February 28th, 2018

RE: Swauk Valley Conservation Short Plat (LP-17-00007) - Request for Additional Information

RE: Swauk Valley Ranch LP-17-00007 (Correction to comments submitted 2-15-18)

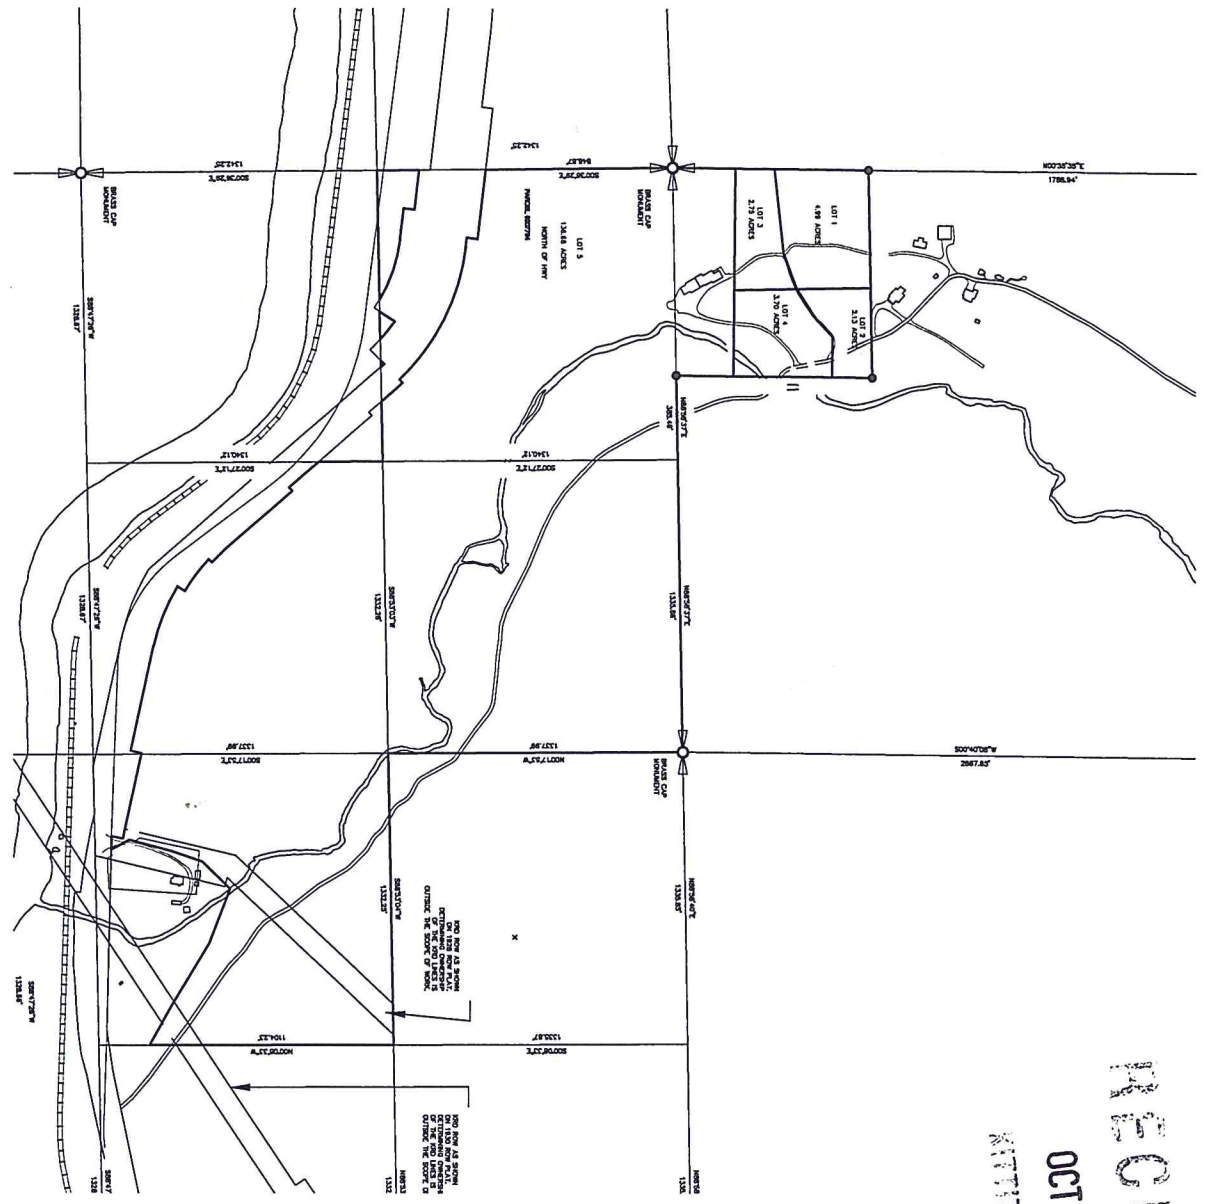
1. Confirmation that the water connections referenced in the plat narrative are not new connections, and thus will not exceed the number of approved connections.
2. A revised plat drawing showing shoreline buffers and ordinary high water marks, critical areas buffers, and their locations in relation to the building envelopes as per the Kittitas County Shoreline Master Program 5.2(C)(3).
3. One soil log shall be performed and information recorded for each lot within the proposed subdivision. Soil logs shall be in accordance with WAC 246.272A (KCC 16.12.030).
